# Comments for Planning Application 24/00171/OUT

Application Number: 24/00171/OUT

Address: 24 High Street Cullompton Devon EX15 1AA

Proposal: Outline for the erection of a dwelling with some matters reserved and additional parking for No 24 High Street

Proposed Site Plan
scale 1:200

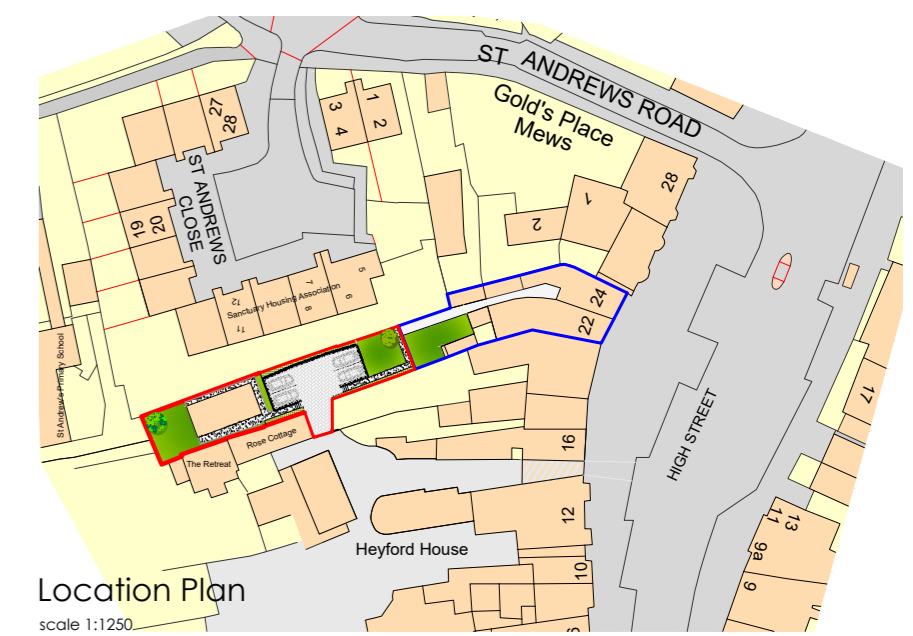
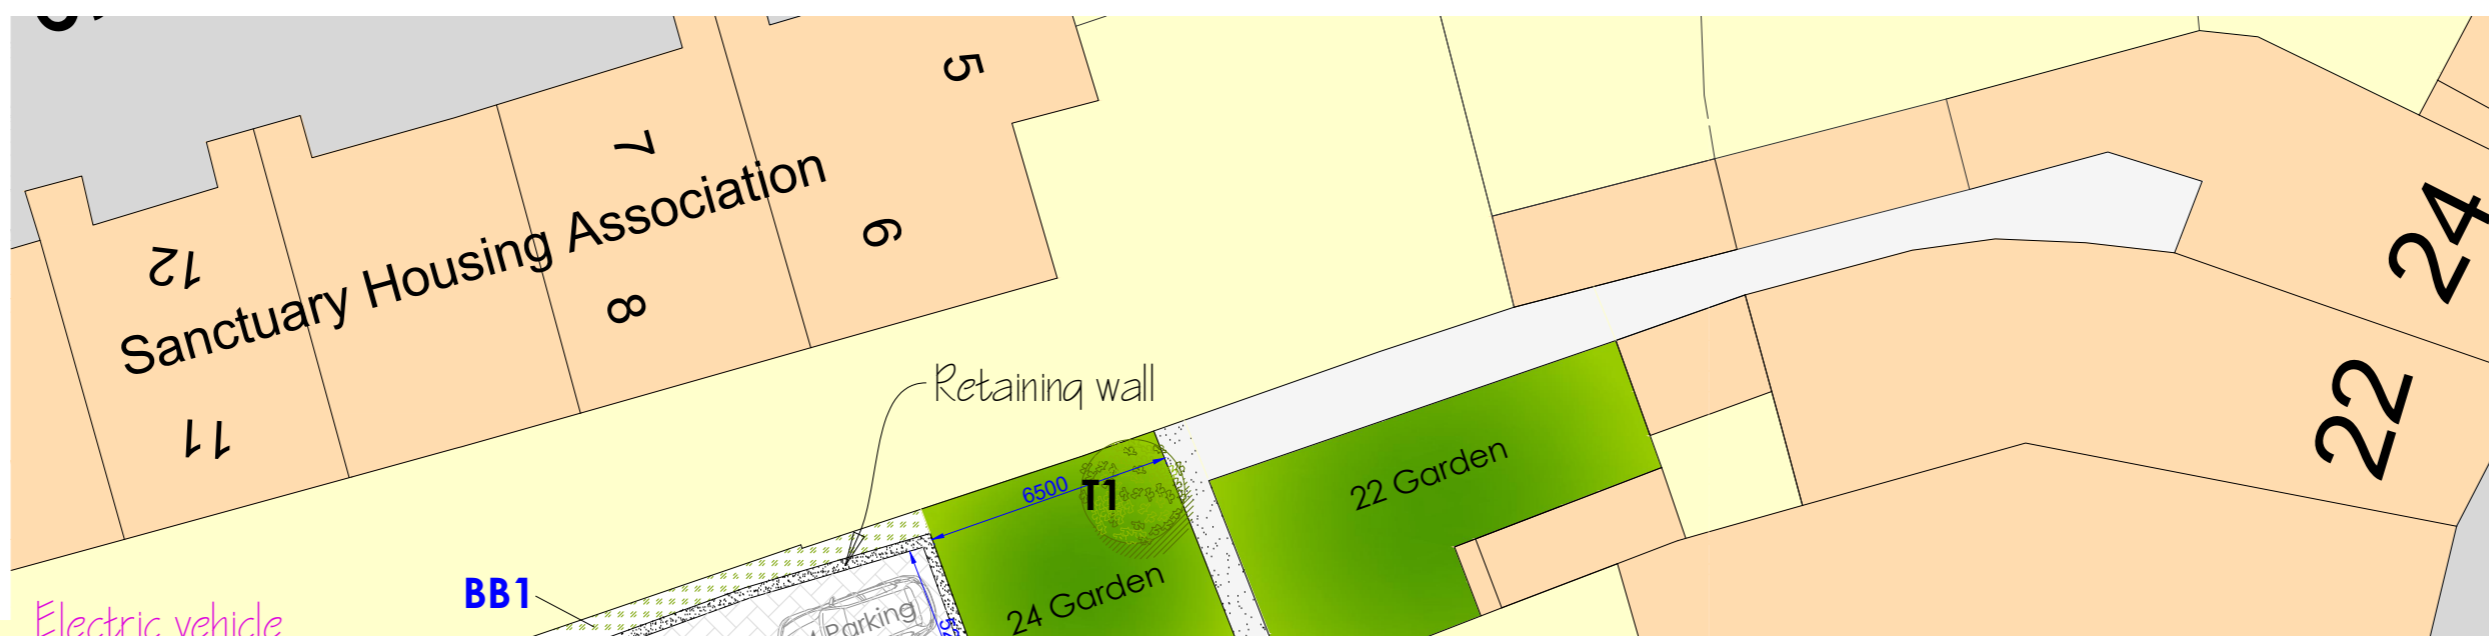
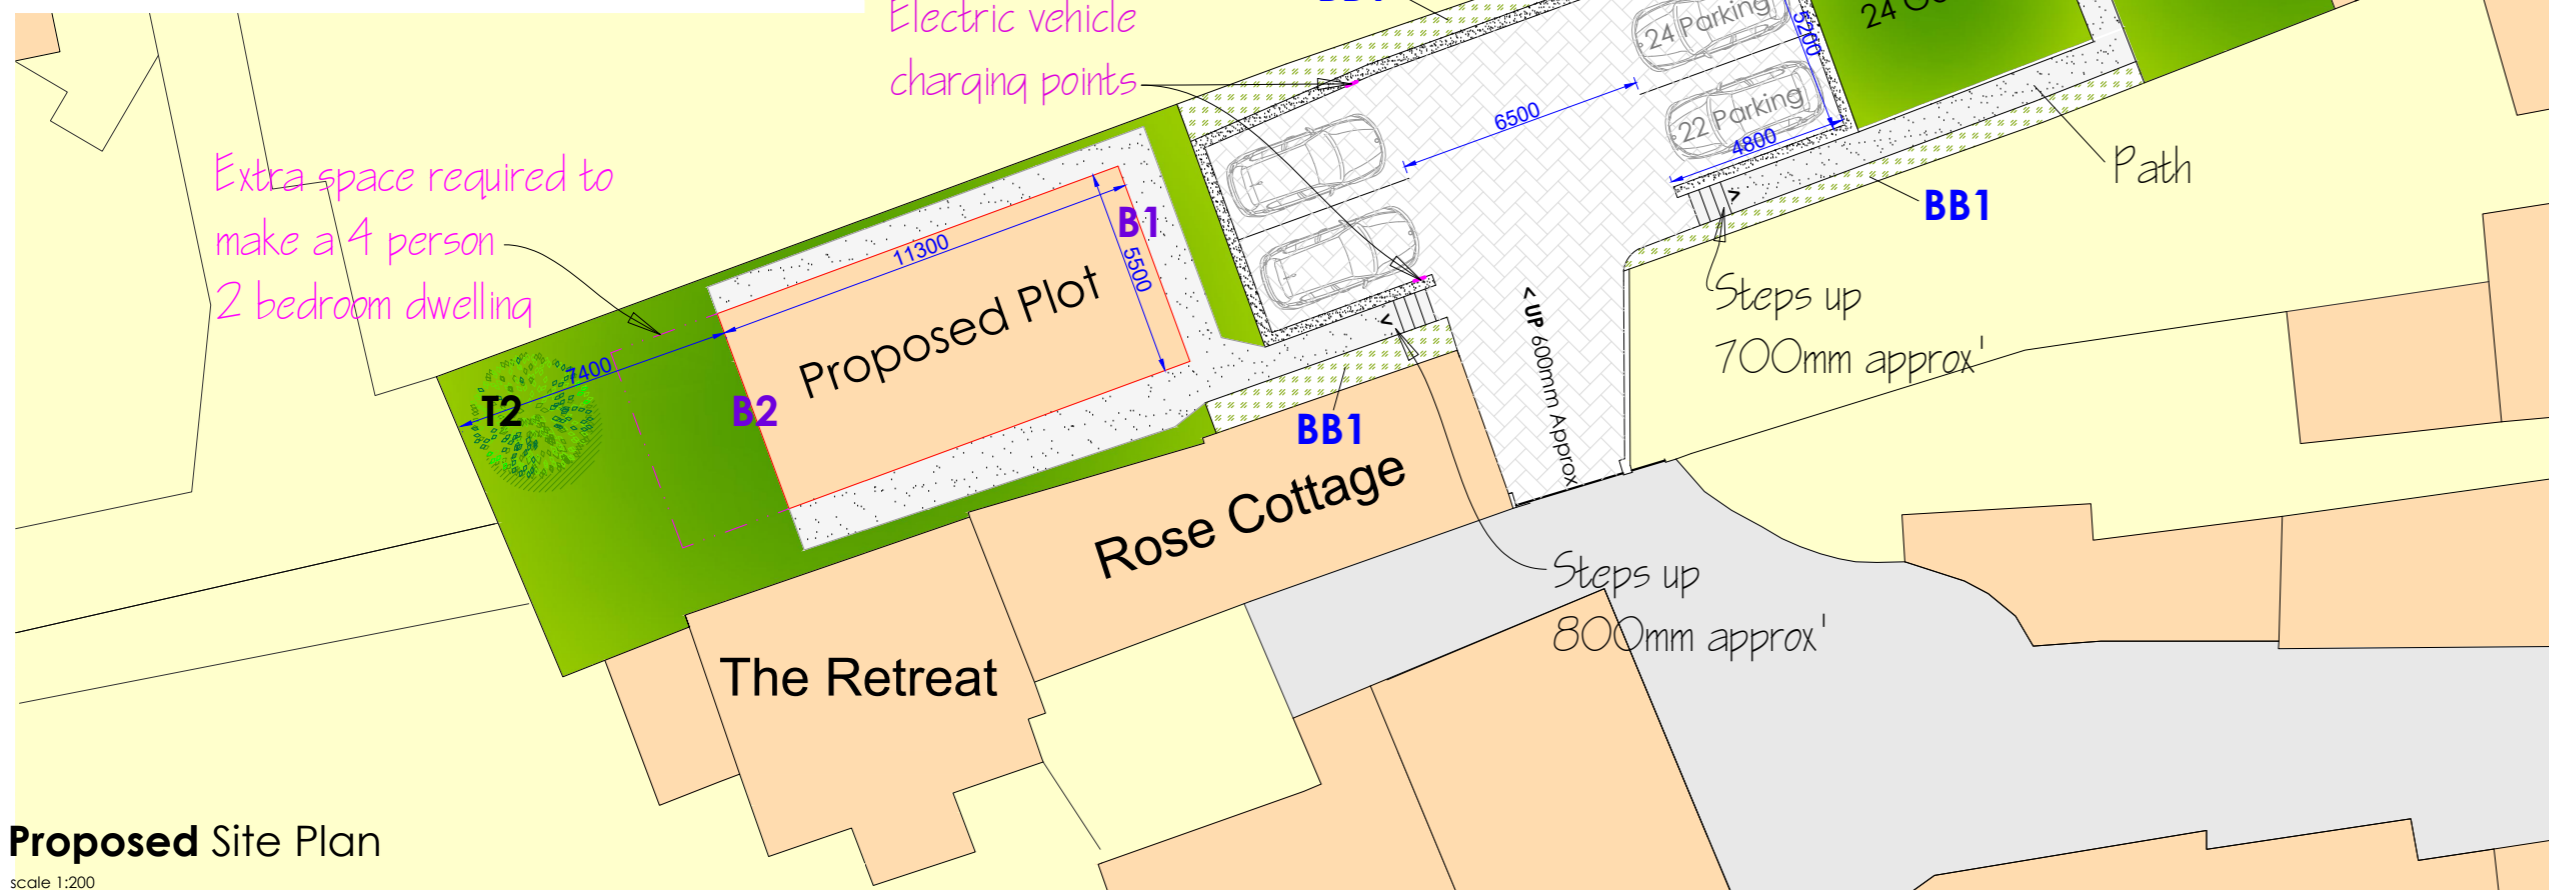
Comment: We strongly object to this proposal, Our property Rose Cottage, is adjacent and connected to the garage that will be demolished and could damage our property, the garage is also slightly offset and behind Gidley Coach House, making it very difficult for a car/s to get in and out of the access, especially when the owners of Gidley Coach House have their car parked there.

The garage is approx 7ft wide and the surface at the back ground level is some 6ft higher at least than at the front of the garage. Are they to remove tons of garden soil to level the parking area, or try to grade it? There is certainly not room for a van larger than a transit to get up the alleyway from the high street. Building materials will have to be dropped at the entrance of the alleyway, in the High street and taken up to the site somehow.

There will really not be room for 4 cars and if they can be squeezed in, there is no turning room and so will need to either back in or out which will be nearly impossible. The aerial photo showing a peach colour where the driveway will be, and the garage currently is, is in fact not at all accurate, or as straightforward as they are showing it, as I said before it is in fact partly behind Gidley Coach House. This is also the access and only access to our Cottage.
